From: Arun District Council Greenspace

Application ref: LU/61/22/PL

Description: New Fibre Broadband Exchange (Use Class B8 Storage and Distribution). This application is in CIL Zone 4 (Zero Rated) as other development.

Location: Linden Park Recreation Ground Littlehampton BN17 7BS

Drawing Title
PROPOSED SITE PLAN

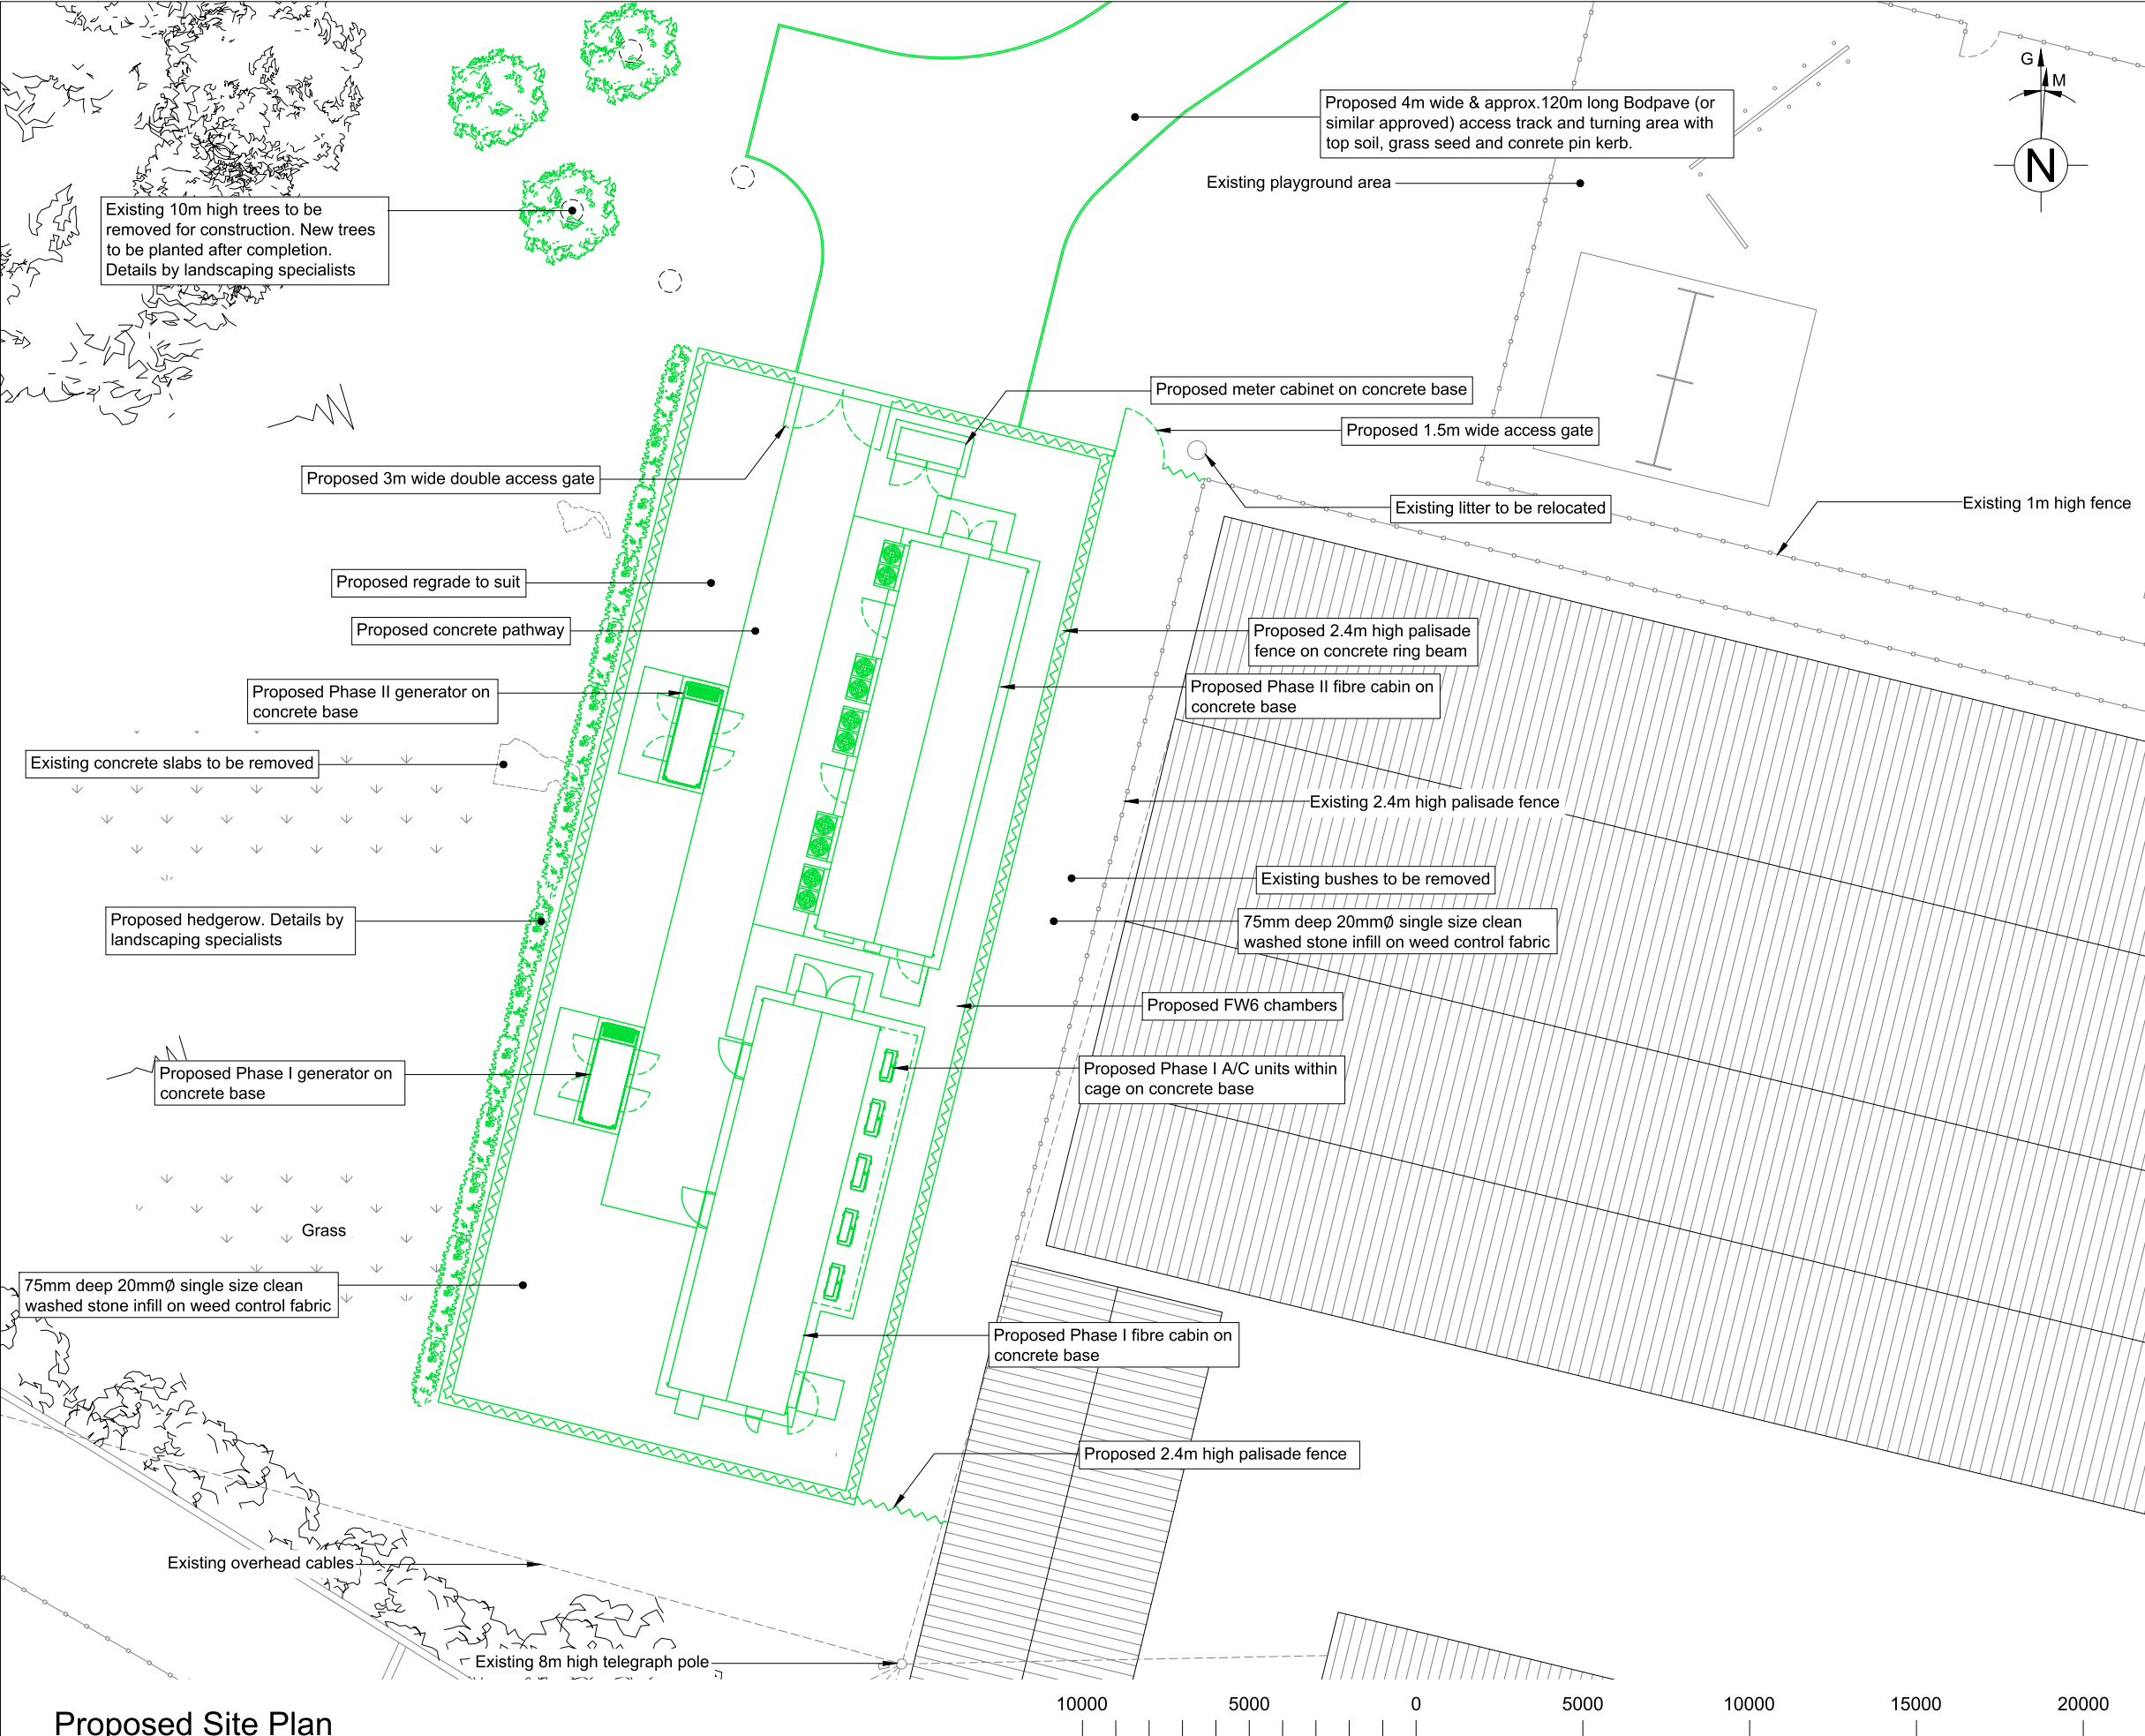
The access material proposed is a 'Bodpave' cellular grass reinforcement product with pin kerb edging which would need to be installed as per manufacturer's instructions and to ensure a seamless finish across the area. This form of access surface would minimise the impact on the POS. This would have the dual benefit of improving overall accessibility for maintenance vehicles and pedestrians using the site. The new access would also enable the possibility of larger events to take place, therefore enhancing and maximising the potential of the recreation ground..

The facility would need to be suitably landscaped to fit the surroundings as part of the proposal. The detail presented within this application states *proposed hedgerow – details by landscaping specialists. Existing 10m high trees are also shown to be removed for construction with detail of New trees to be planted after completion – Details by landscape specialists*. This detail has not been included within the application and would require submission for approval or conditioning with any decision.

Maintenance through to establishment of the cellular grass roadway and the mitigation tree and hedge planting would need to be ensured with maintenance operations and plant establishment details approved.

Recommend further landscaping detail needs to be submitted for approval re the mitigation planting required for screening and greening of this facility within this open space area.
